**New Liverpool Primary School (SSD-10391)
Response to submissions report**

Attachment 1 – Key Issues

RD1 - ROLLER DOOR METAL CANTEEN
RD2 - ROLLER DOOR METAL HALL
SH - METAL FRAMED SUN SHADING
SM - WINDOW SECURITY MESH

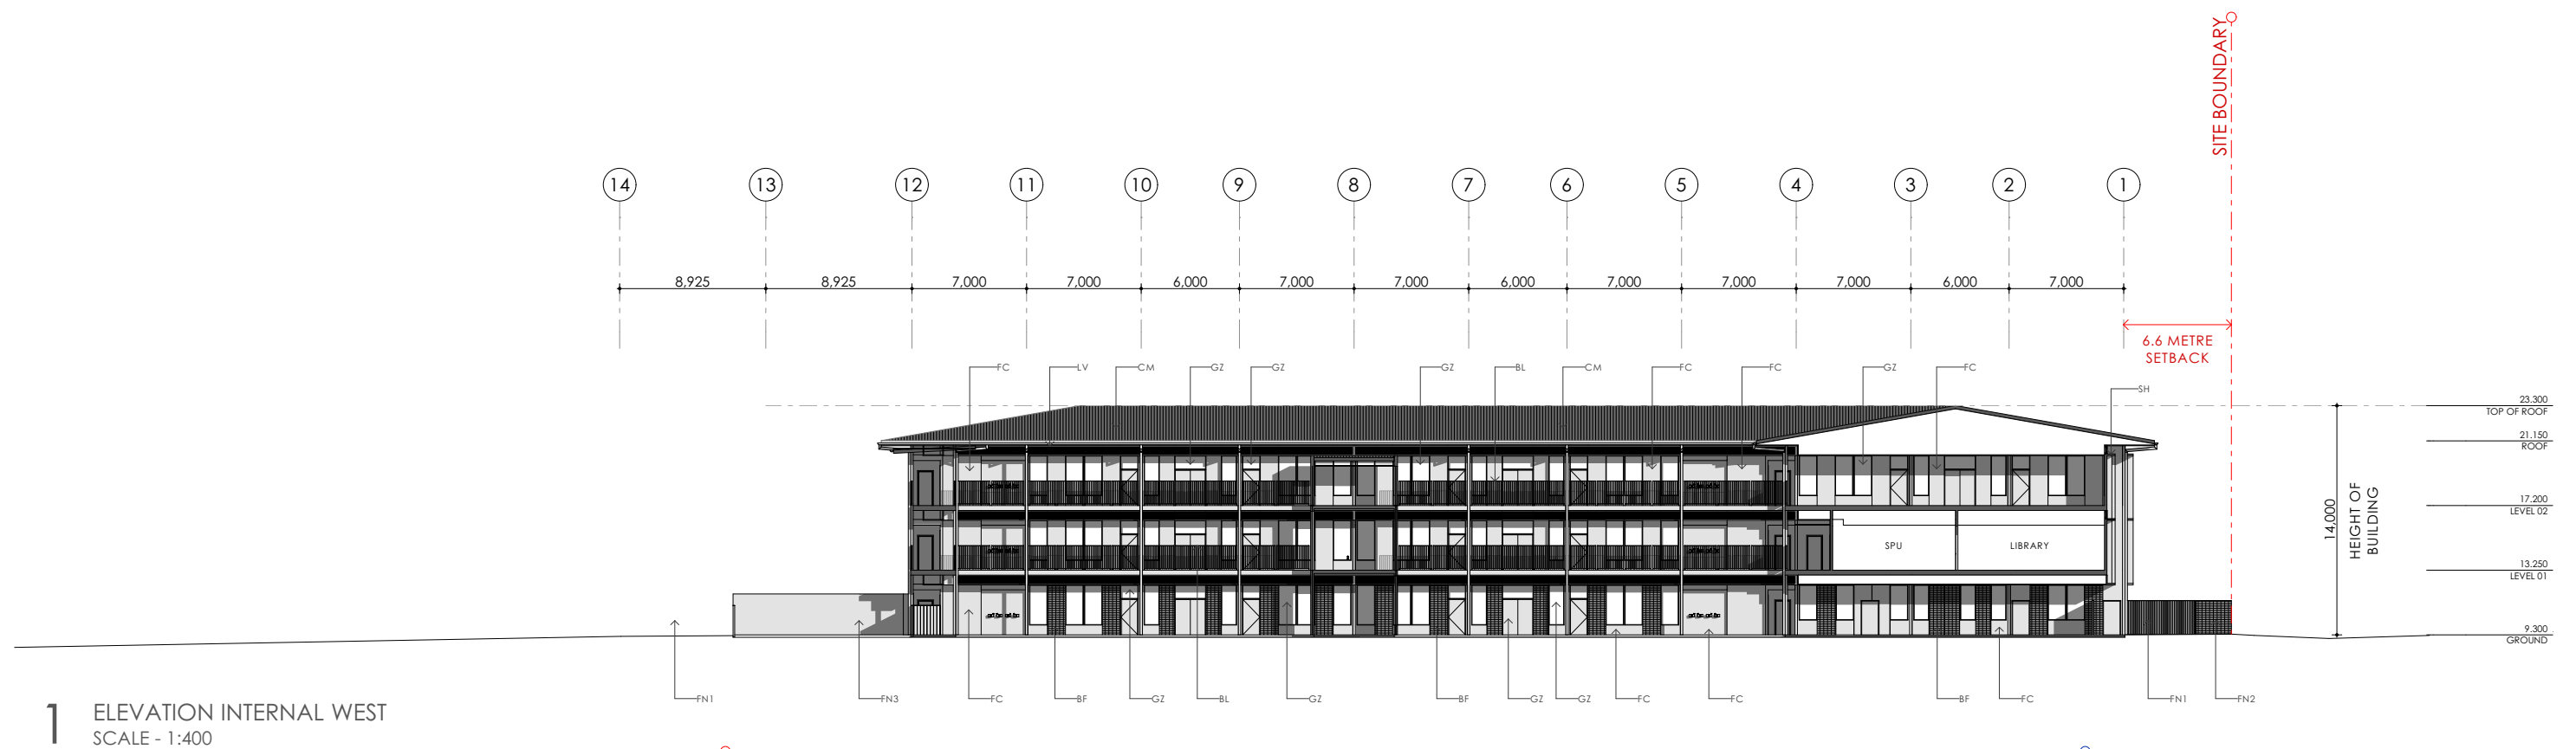
- Government Architect NSW (GANSW) have reviewed the EIS and have raised concerns regarding the full height glazing to the Western façade with no shading and no planting able to be facilitated along the boundary. In recognition of the western elevation, you are requested to address this issue and provide additional shading devices or articulation of this façade which can result in shading.
- Please provide details on the proposed future east/west link through the site, even if it is not finalised as yet, to demonstrate the site permeability.
- GANSW have raised concerns that the 'breakout' balconies have been deleted with only one outdoor learning space on level 01. You are requested to address this issue, include reasons as to why all of the upper level balconies have been deleted and provide details of outdoor learning areas on this level.

NEW ROUNDABOUT

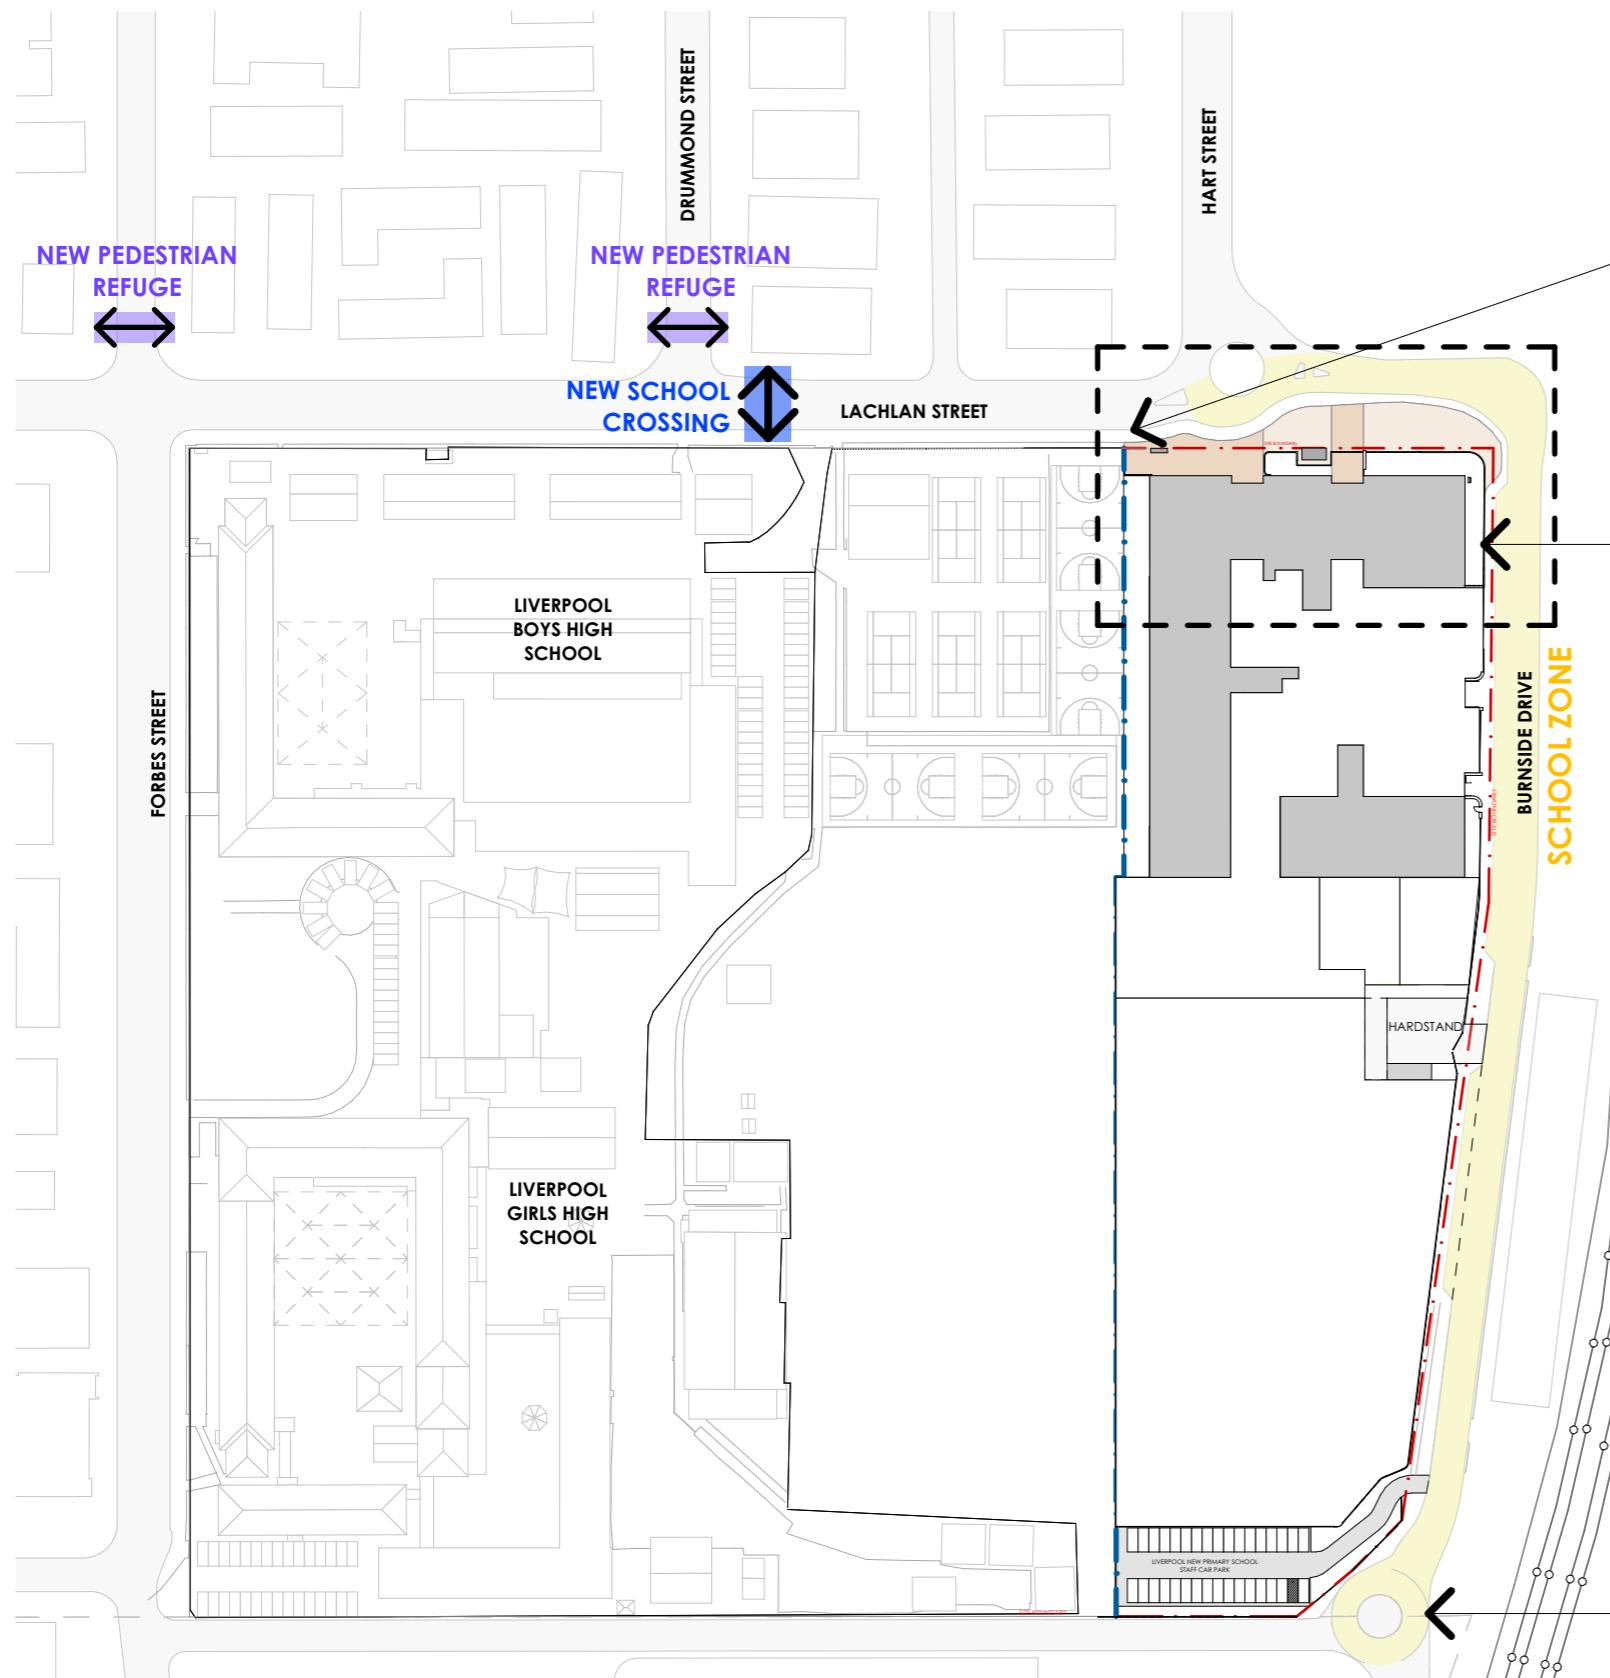
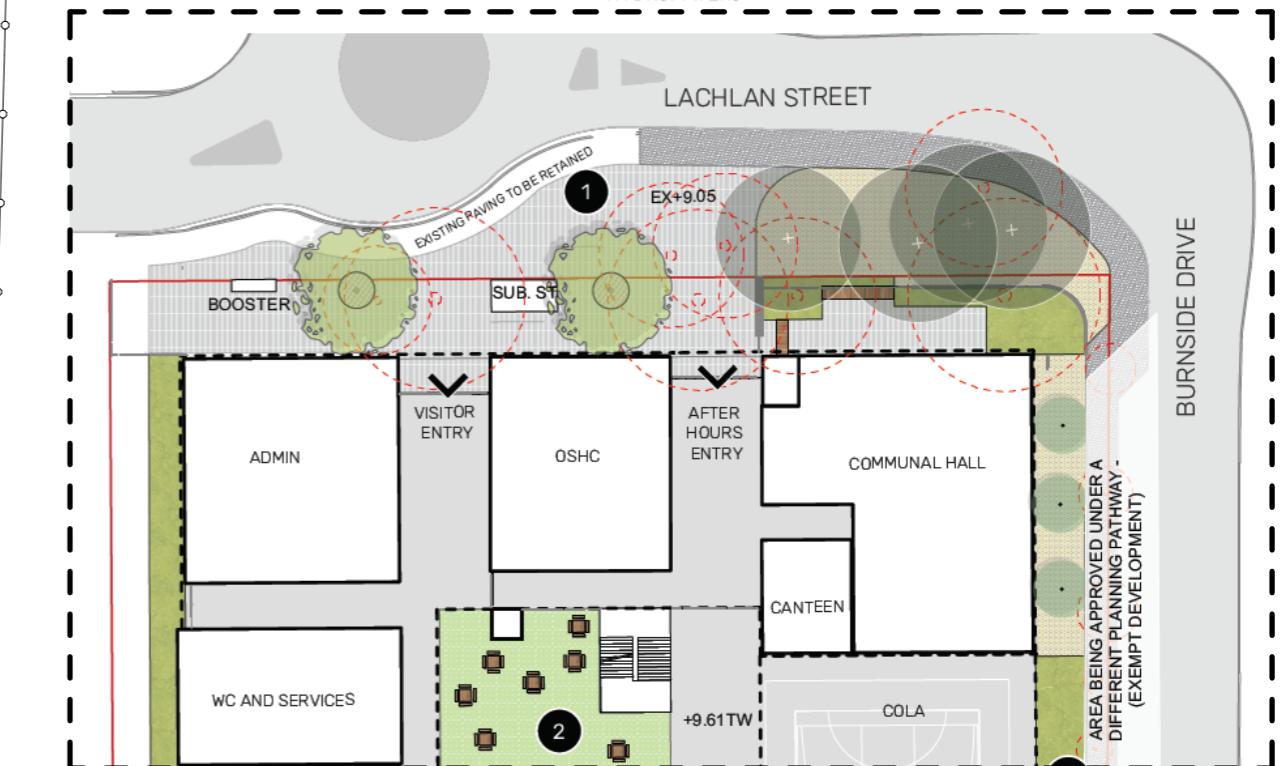
- The EIS states that the project team is liaising with Health Infrastructure on the adjacent road network and a new roundabout will be installed as part of the project to provide access to the school drop off zone on Burnside Drive. The roundabout would be delivered under a separate approval partly on the Liverpool Hospital land. Part of the roundabout appears to be within the school land as well. In this regard, please confirm:

- whether the roundabout would be delivered along with the widening of the Burnside Drive prior to the school opening in 2023 (this is the recommended option).

- the consultation process with SWAHD / TfNSW with regard to delivery of this roundabout.
 - whether any boundary adjustments would be needed as part of the school land appears to be utilised for the roundabout.

- whether the roundabout and the road infrastructure would be dedicated back to Council for future management.
 - how would cars be prevented for making a U-turn on Burnside drive while dropping / picking students.
